Application No: FG/54/22/PL
Site Address: Land rear of 1 Sea Drive Ferring BN12 5HD
Description of works: 1 No new dwelling. This application is in CIL Zone 4 and is CIL Liable as new dwelling.

Ferring Conservation Group objects to this 'house-in-a-back-garden' application, for the following reasons:

Proposed Site Elevation
Scale 1:200 @ A1

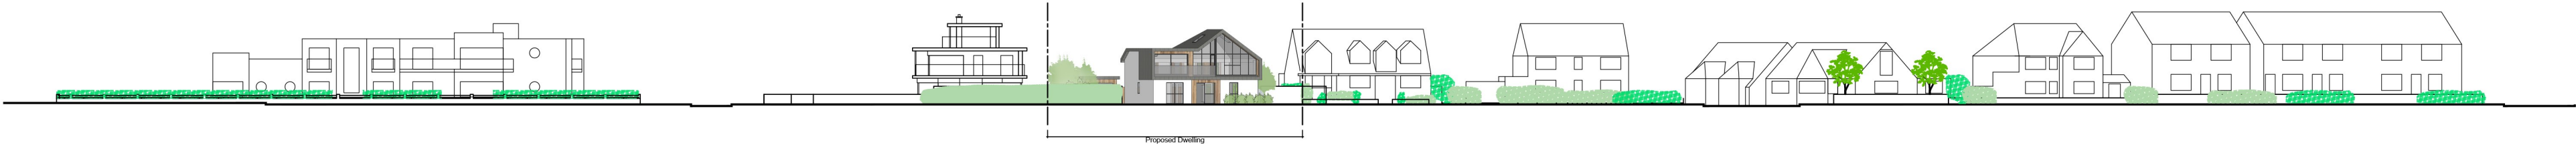
- 1.The development does not respect, let alone enhance the character of this part of Sea Lane. The applicant has already spoiled the character by the second-floor box extension to the existing house. The massing of the two buildings would be unsightly in the street scene and from the fields of the Goring Gap.
- 2.Both houses would be left with very little garden space.
- 3.The development would create a road safety hazard. It is on a blind bend in the road, invisible to traffic going south.
- 4.

Proposed Site Plan  
Scale 1:100 @ A1

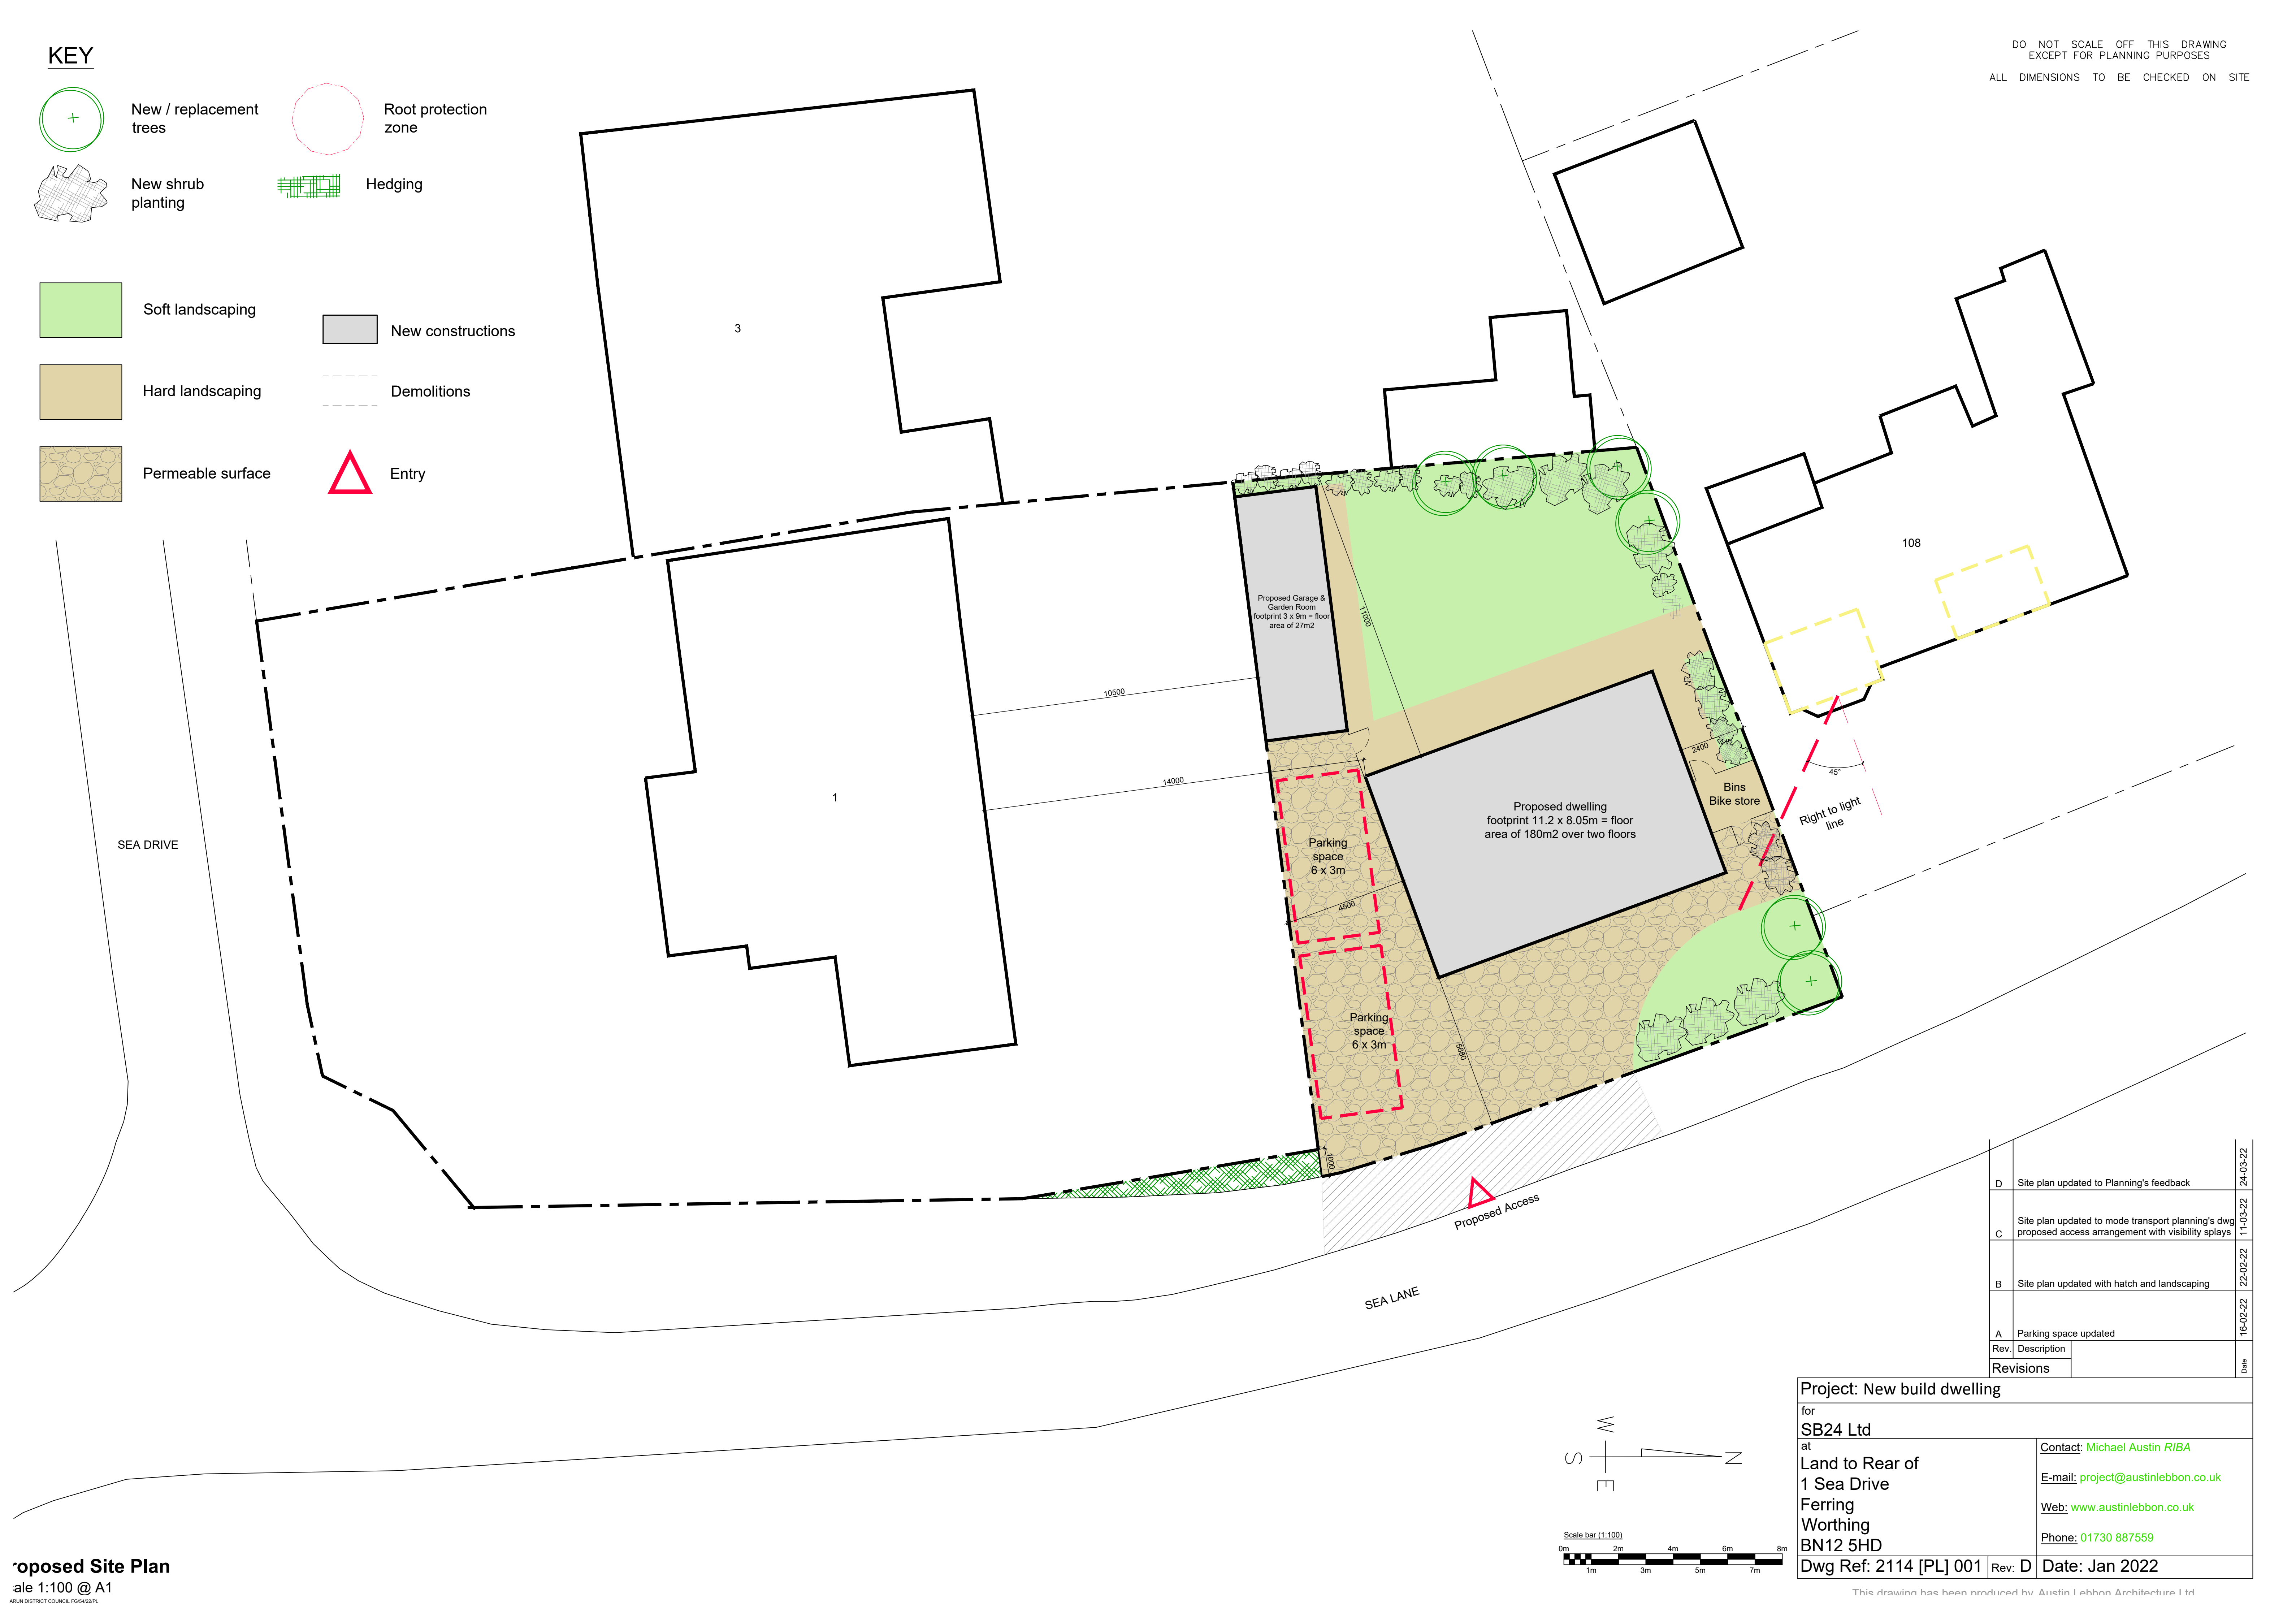
It is not clear how vehicles parked in the garage or the two parking spaces in front of it could enter and leave in forward gear. No turning space is shown.
